Application by Highways England for a Development Consent Order in relation to the A585 Windy Harbour to Skippool Improvement Scheme

The Examining Authority's further written questions and requests for information (ExQ2)

Issued on 23 July 2019

**KEY:**

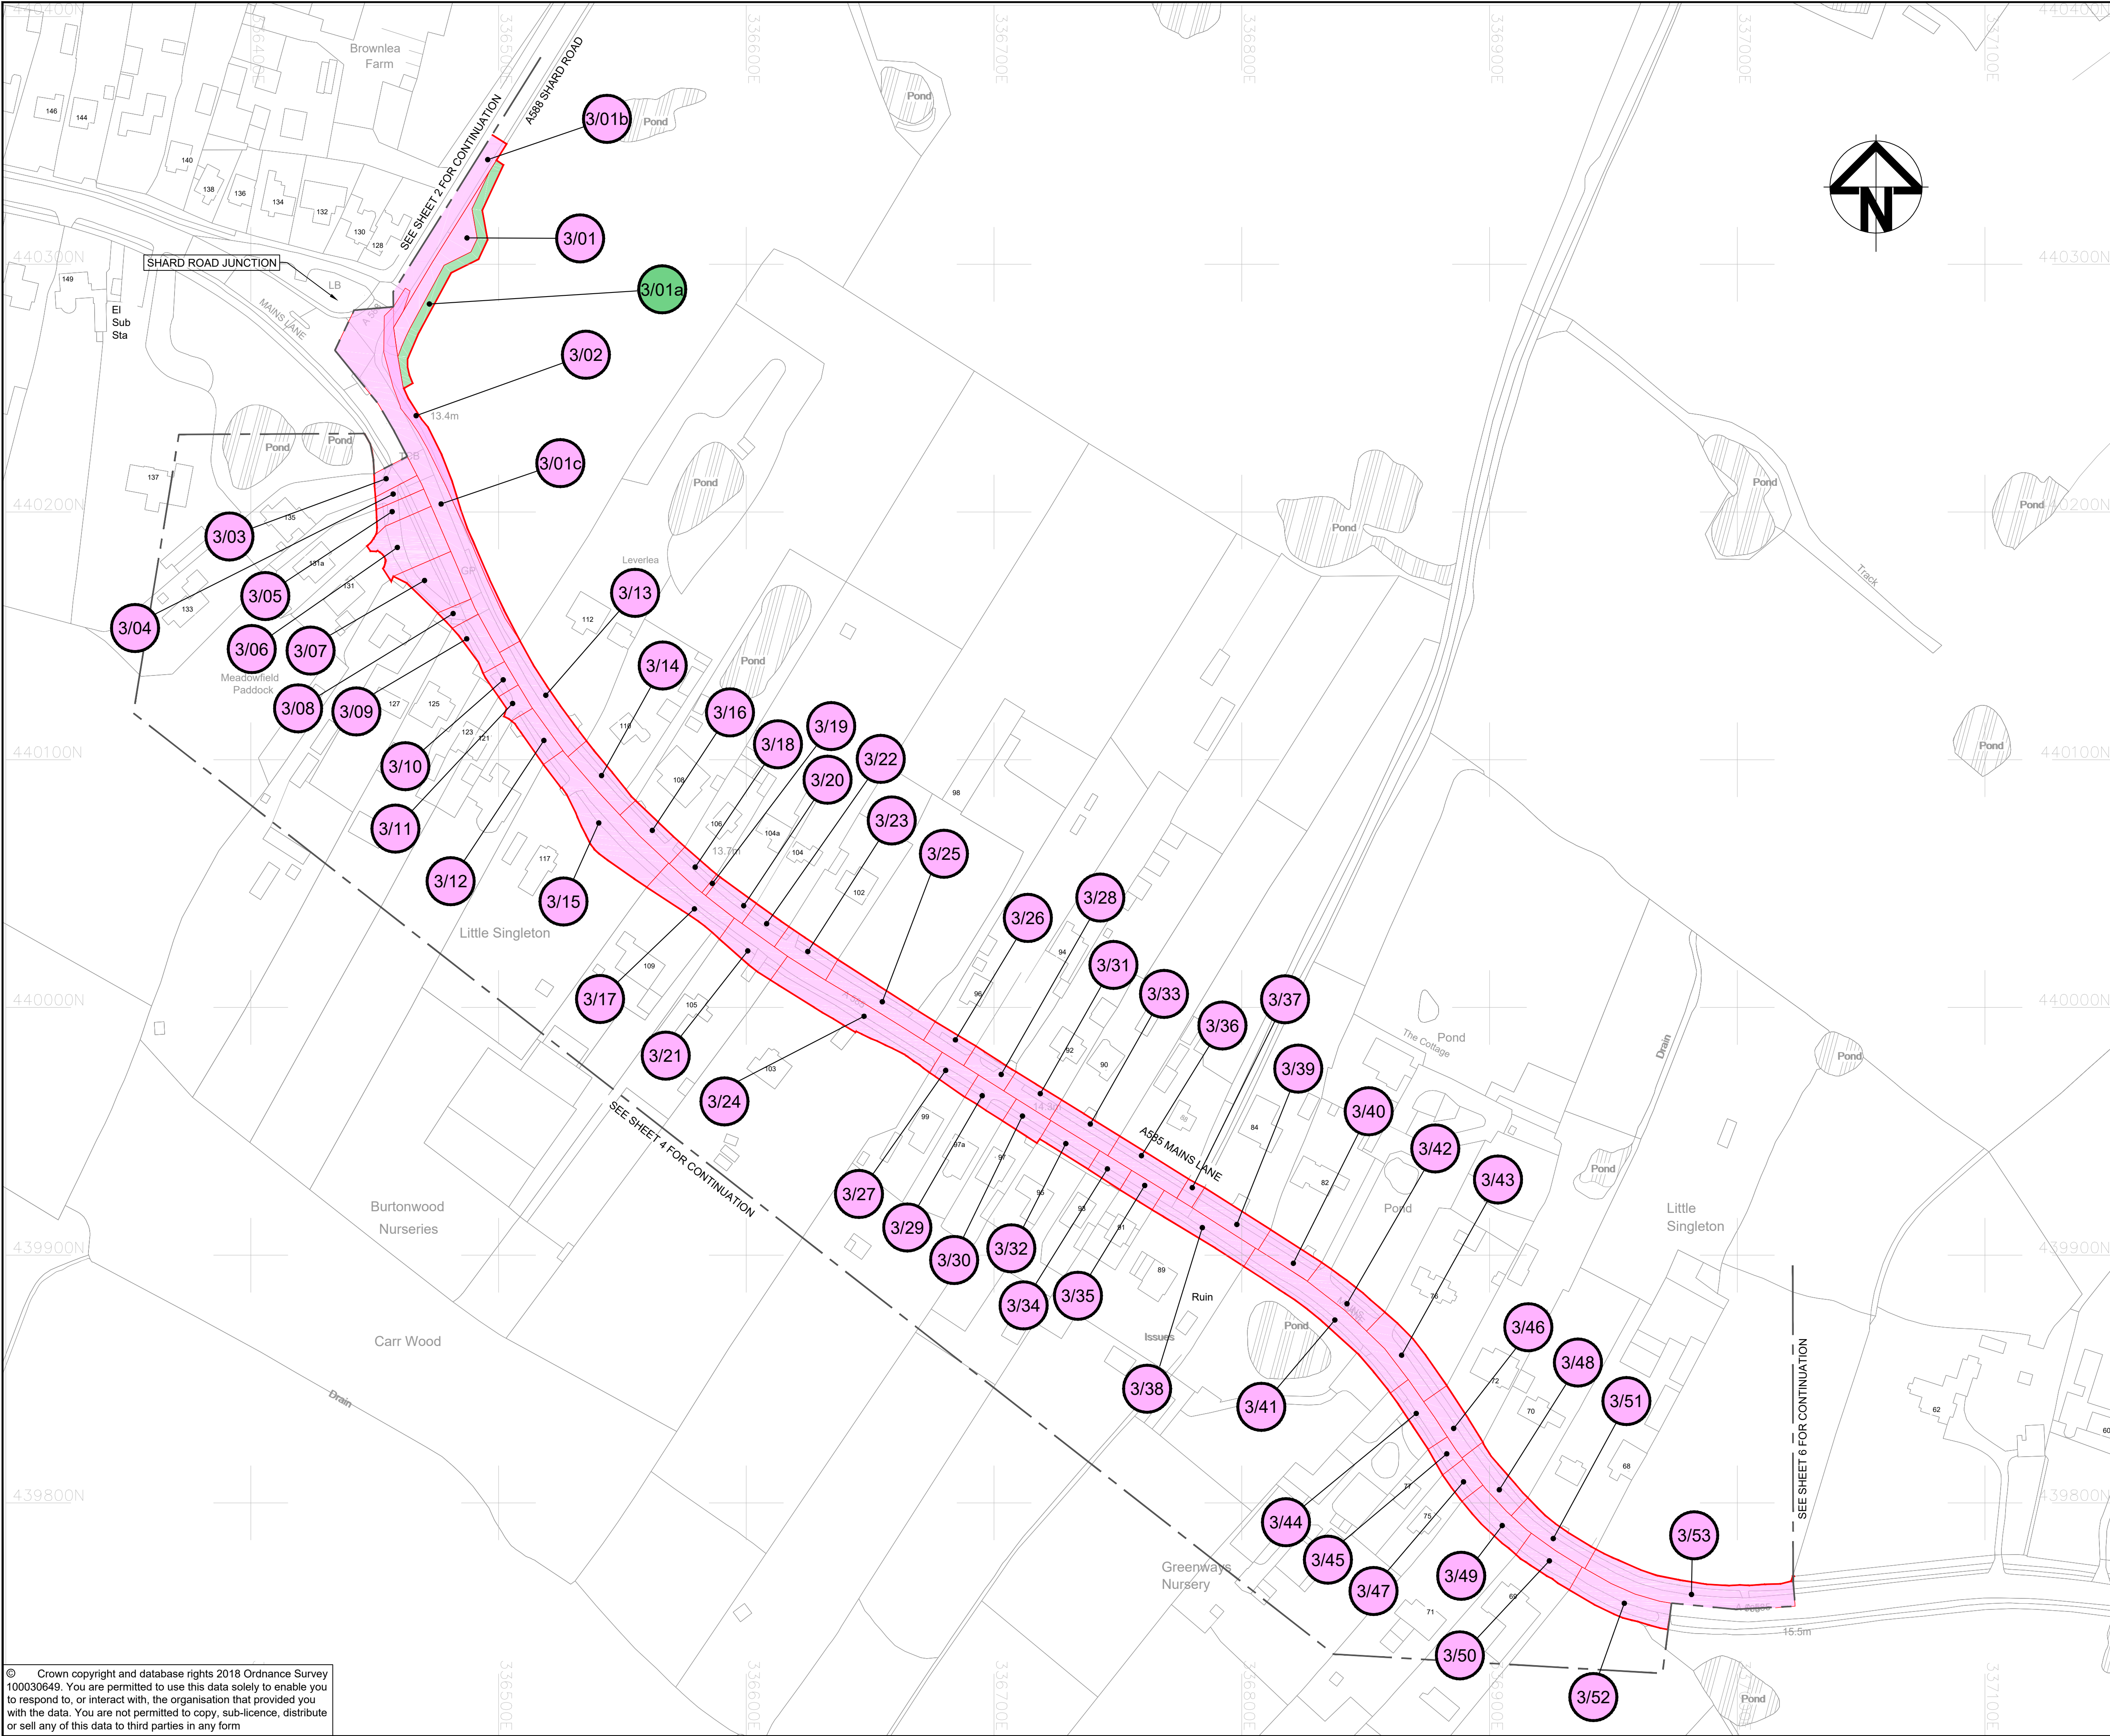
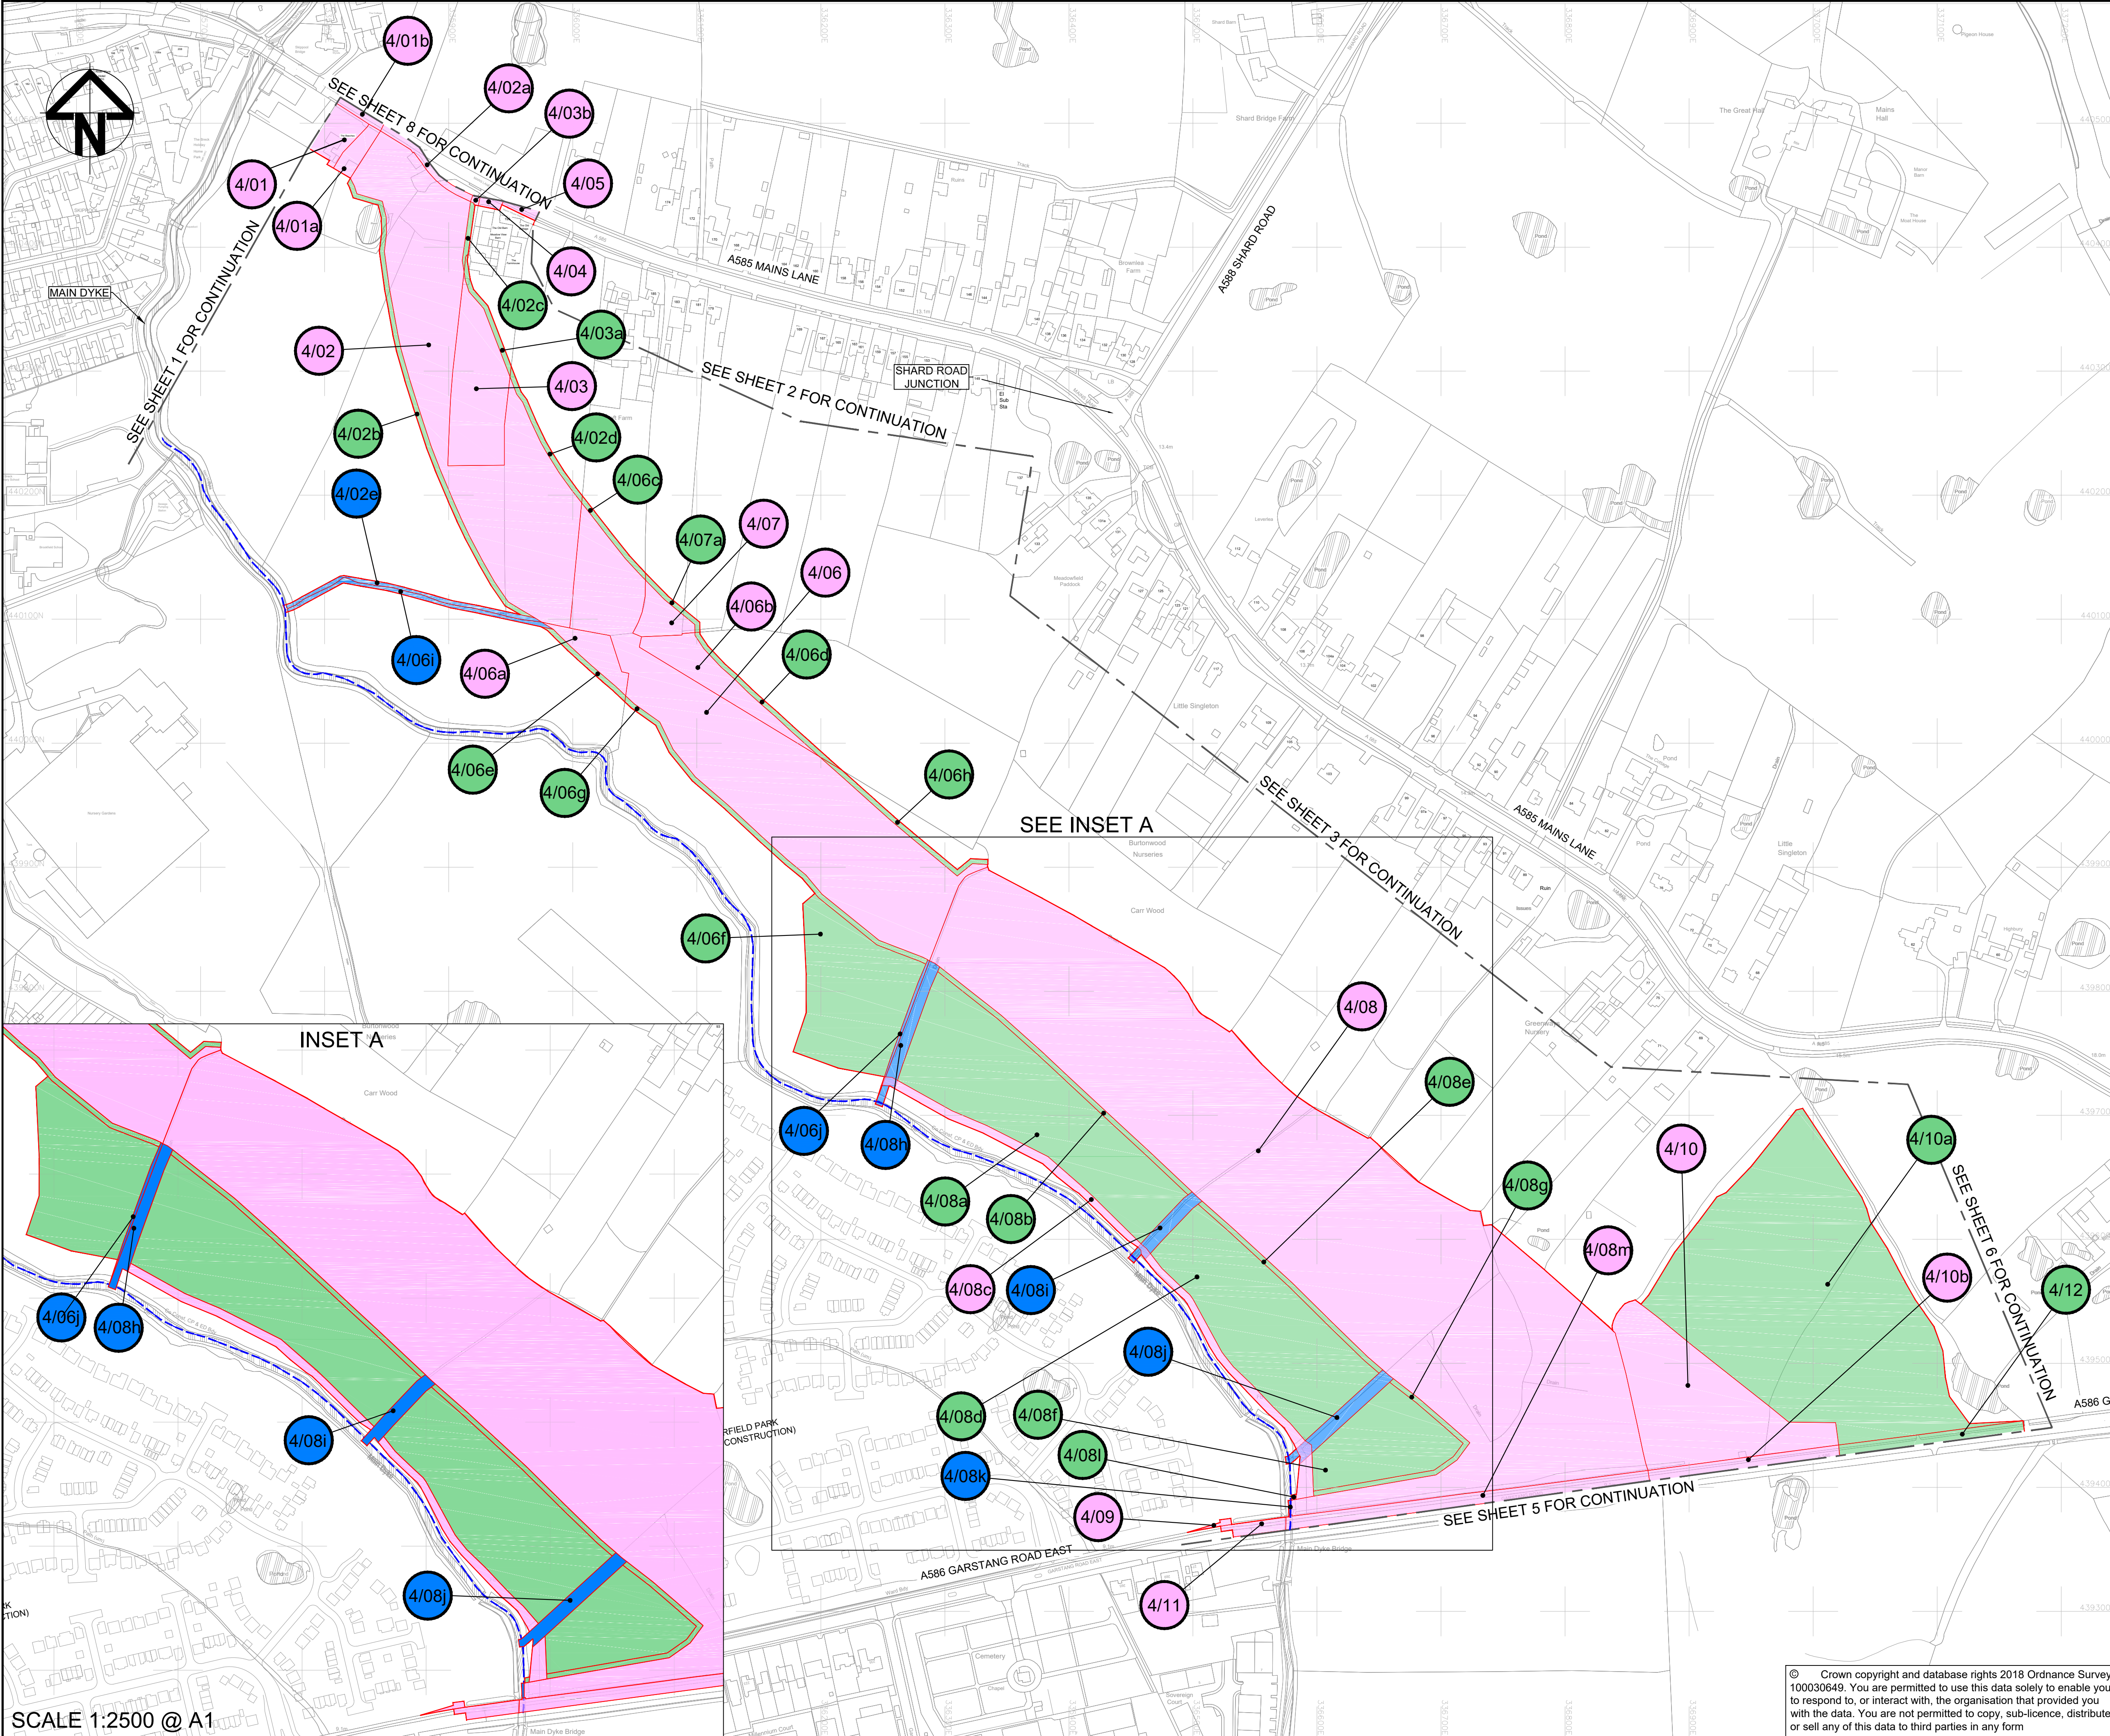
2.2.27.	The Applicant	<p>Area not included in the DCO boundary What is the area identified on the Land and Work Plans in yellow as “area not included in the DCO boundary”?</p> <p>It appears from the plans that this area is within the “order limits” i.e. within the red line boundary on the plan. The “order limits” are defined in the DCO as “the limits of land to be acquired or used permanently or temporarily shown on the Land Plans and Work Plans within which the authorised development may be carried out”. There is no definition of “DCO boundary”. Please explain what the “DCO boundary” is and how this interacts with the “order limits”.</p> <p>Please explain how the area identified as “area not included in the DCO boundary” relates to the dDCO, in particular to the works and CA for which authorisation is sought.</p>
